4. **Project# 1009359**  
12DRB-70305 EPC APPROVED SDP  
FOR BUILD PERMIT

ARIA ARCHITECTURE LLC agent(s) for PEAK MOTION PHYSICAL THERAPY request(s) the above action(s) for all or a portion of Lot(s) 20A, Block(s) 10, Tract(s) 2, **NORTH ALBUQUERQUE ACRES Unit(s) 3**, zoned SU-2 MIXED USE, located on HOLLY AVE NE BETWEEN LOUISIANA AND WYOMING containing approximately .5907 acre(s). (C-19) [*Deferred from 10/3/12*]**THE SITE DEVELOPMENT PLAN FOR BUILDING PERMIT WAS APPROVED WITH FINAL SIGN-OFF DELEGATED TO PLANNING FOR THE FILING OF THE PLAT AND FOR APPROVAL OF THE ADMINISTRATIVE AMENDMENT FOR SITE PLAN FOR SUBDIVISION.**

### HYDROLOGY DEVELOPMENT SECTION DEVELOPMENT REVIEW BOARD MEMO

DEVELOPMENT REVIEW BOARD – SPEED MEMO

AS101

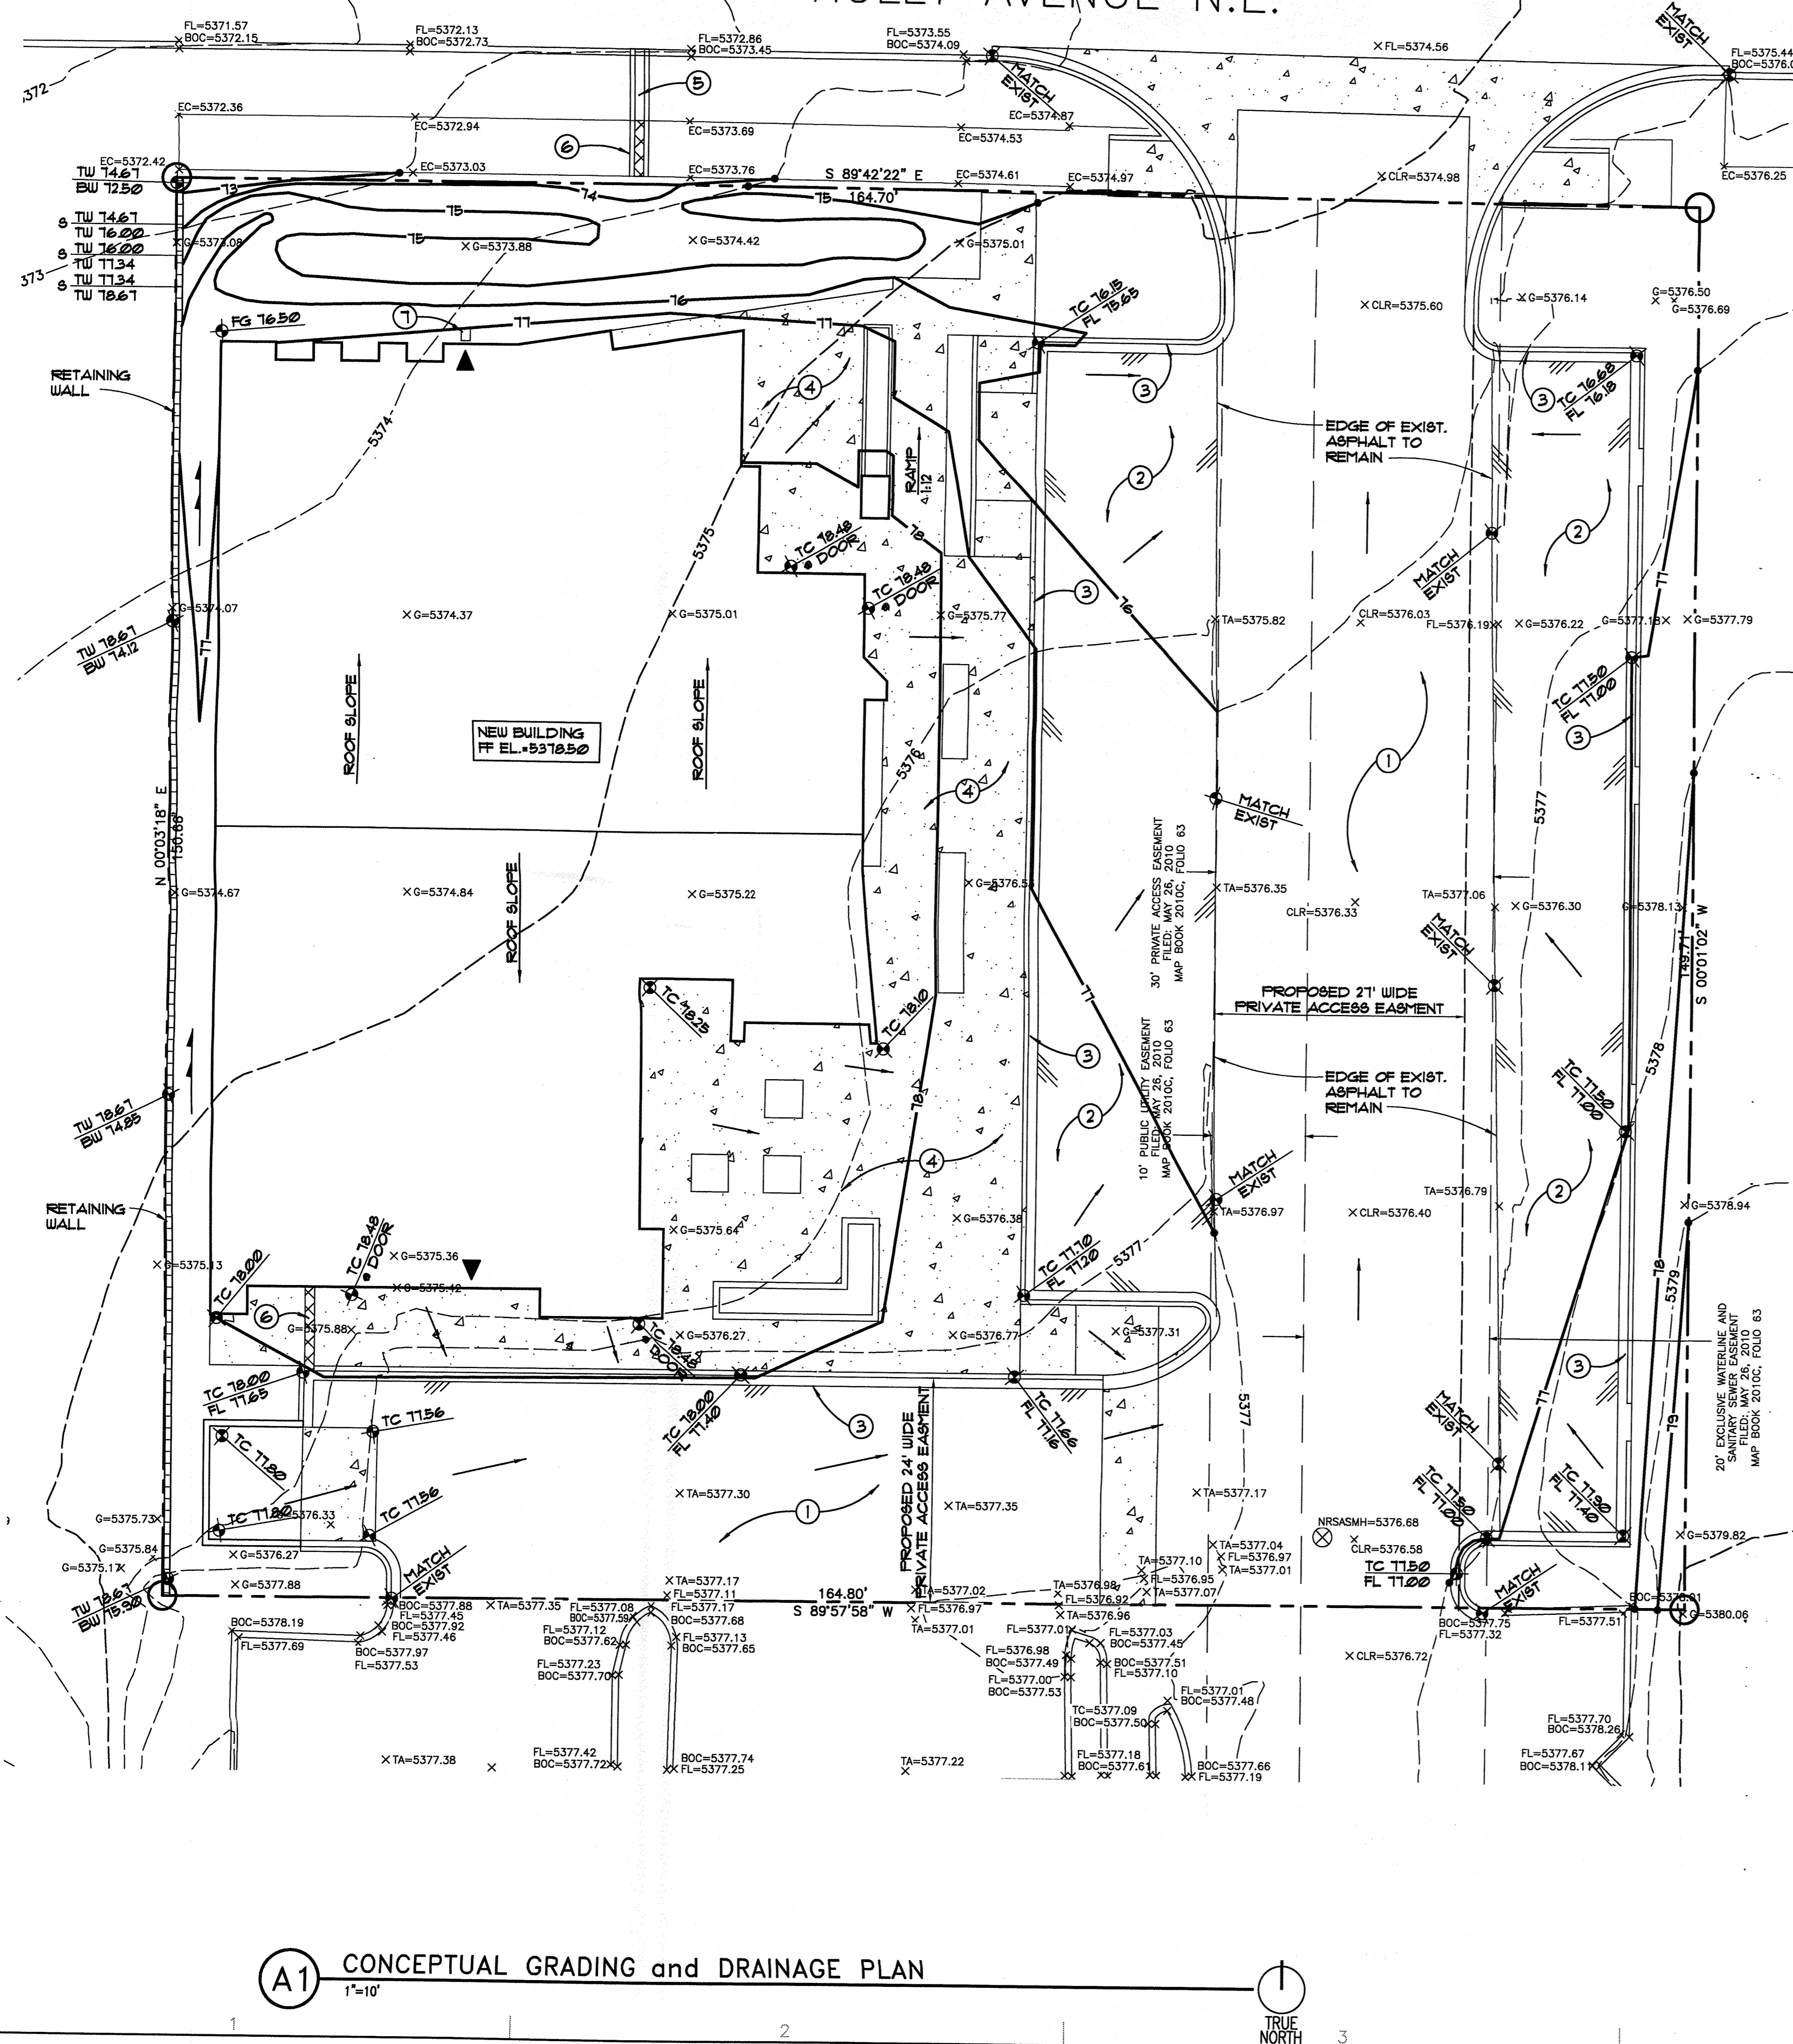
The exhibit provided indicates a portion of the sidewalk along Holly Avenue is missing. This sidewalk must be constructed with this project.

Provide recording information for all easements. If the easement is to be dedicated with the concurrent platting action, please note "to be dedicated with concurrent platting action."

Please note the scale as 1" = 10'.

All ramps located within City right of way must have truncated domes.

The proposed access easement along the Lot 21-A/Lot 20-A-1 lot line must be 24 feet wide with a 15-foot radius at the intersection with the existing access easement. This easement must be defined on the site plan. Please revise the note accordingly.

C101

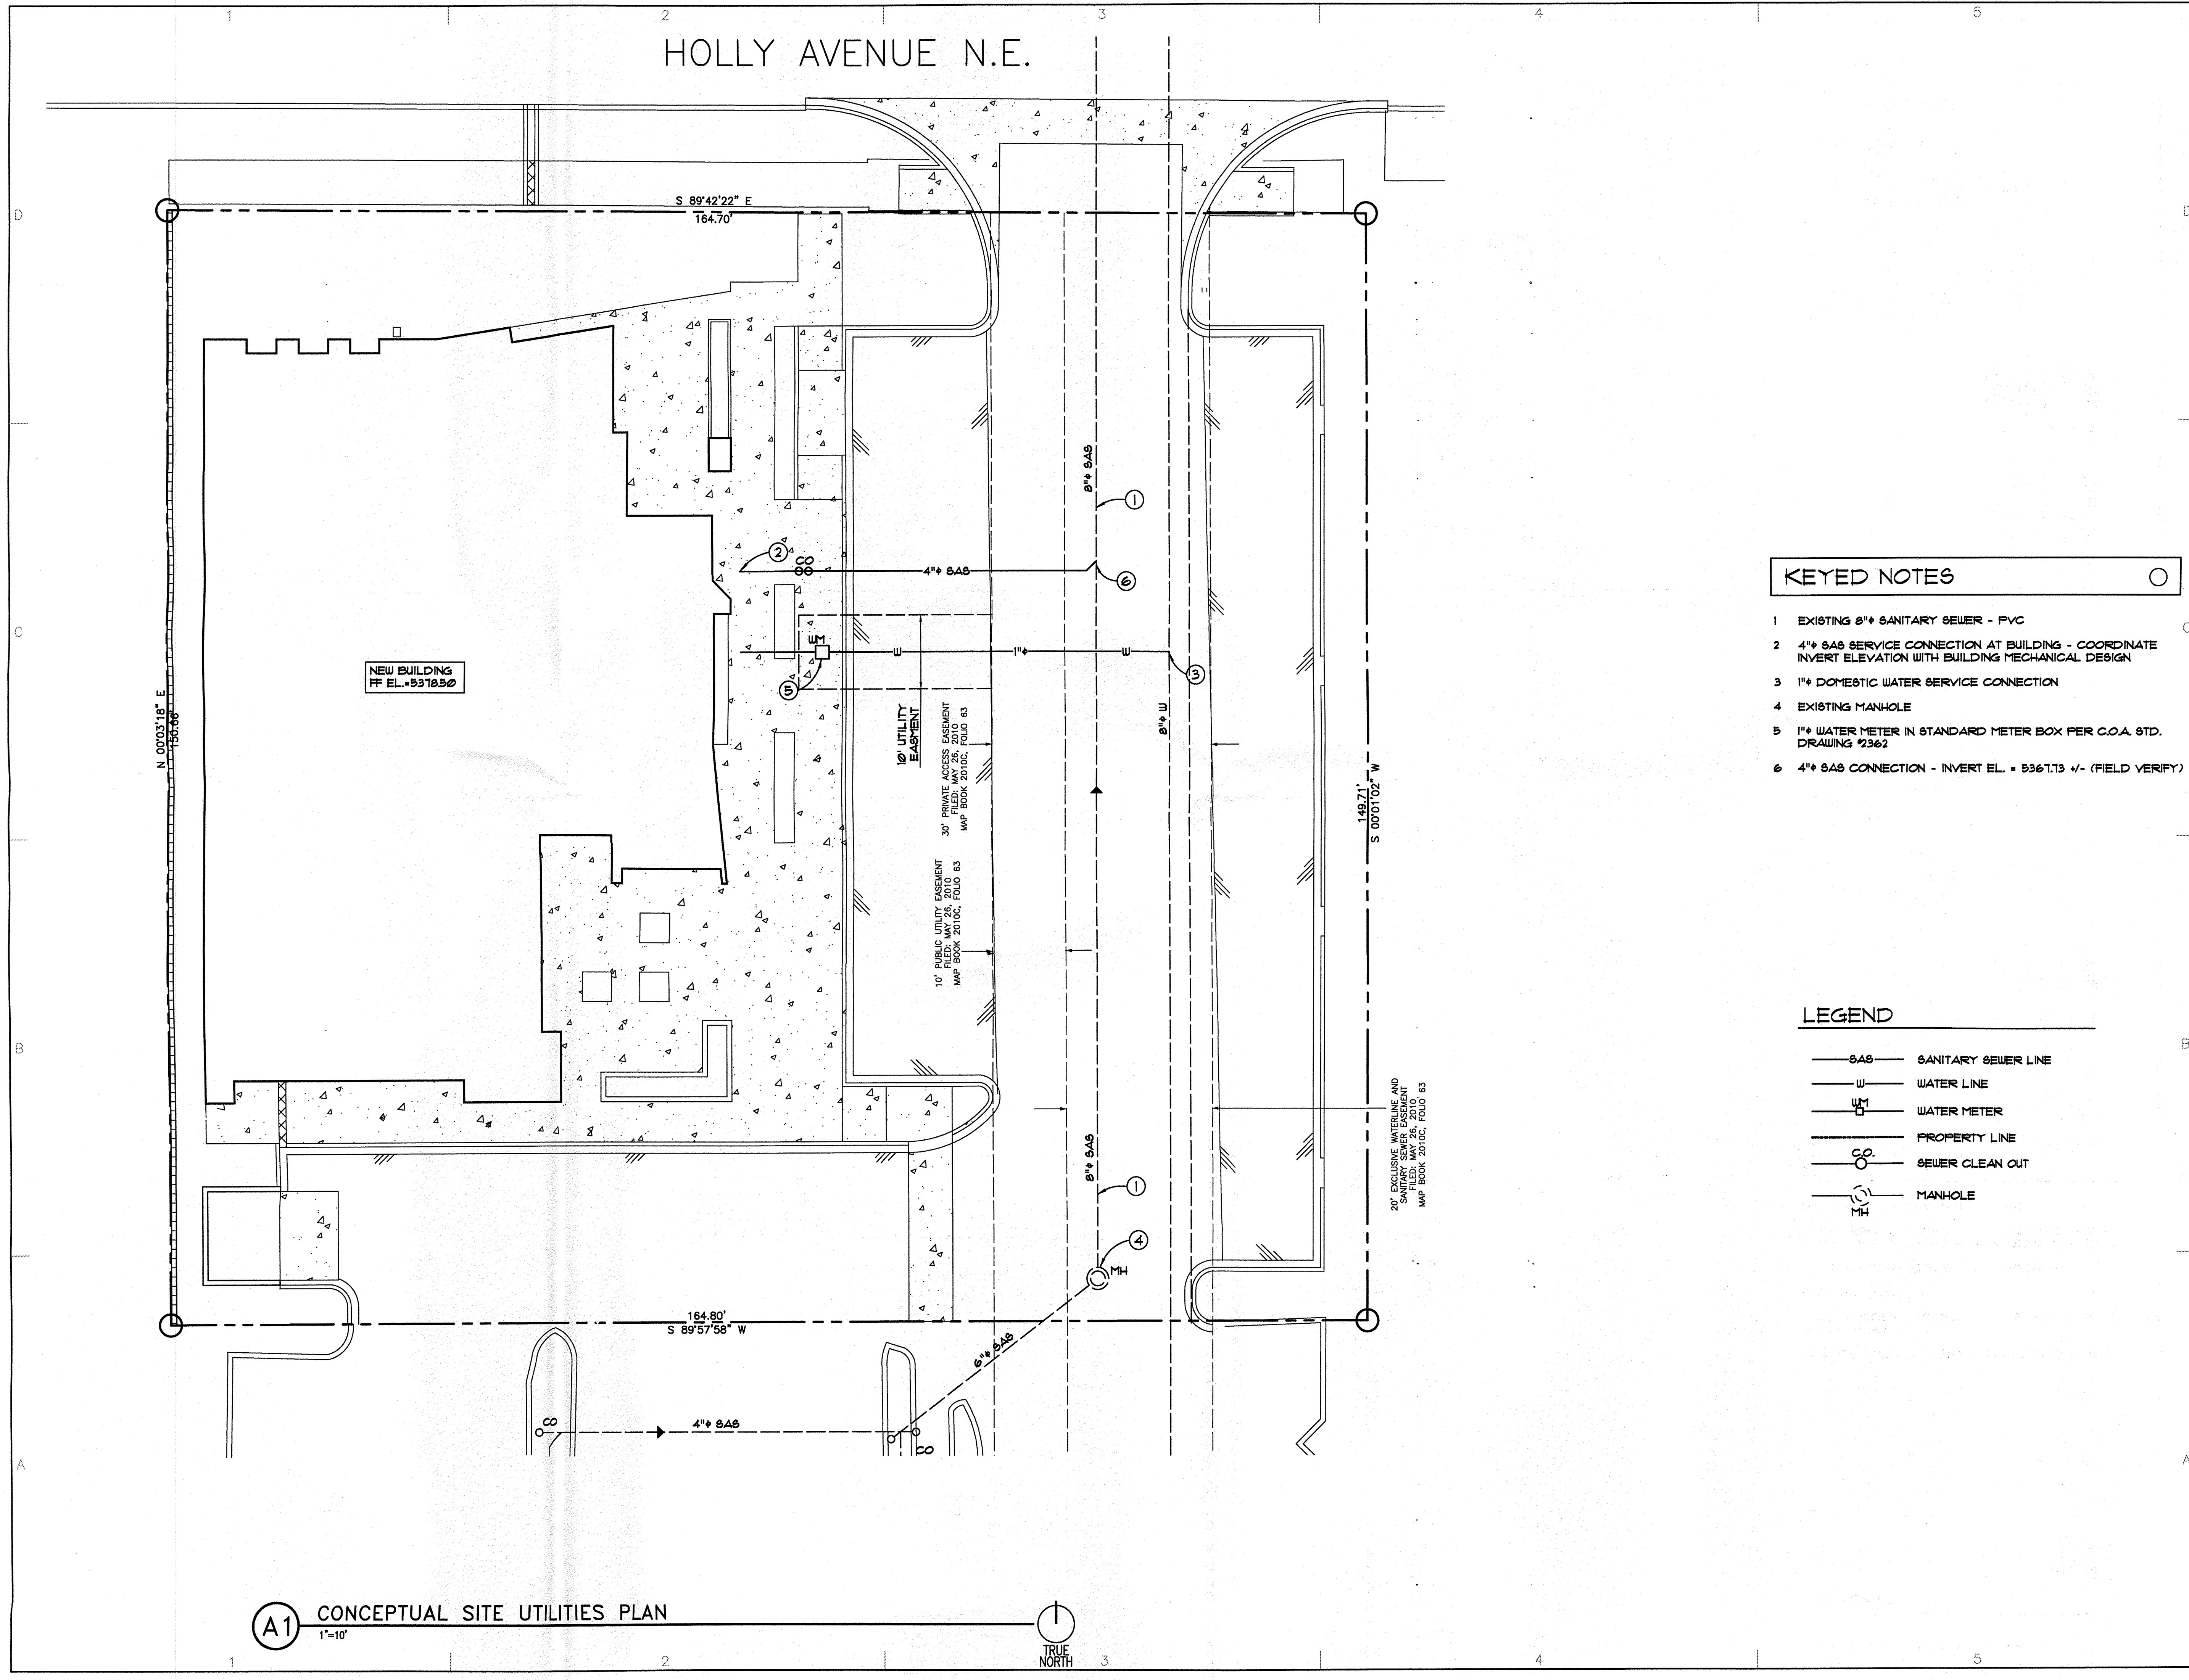
Comments on the grading plan for Building Permit approval:

1. Why isn't the sidewalk culvert proposed near the western edge of the property, since it is the low point. Trying to turn these flows east is creating a steep slope at the back of sidewalk.
2. The plate is required on the sidewalk culvert to the face of curb.
3. Provide TW/BW grades on the retaining wall.
4. Adjust grades to drain a portion of the parking lot to the east landscape area per the site plan.
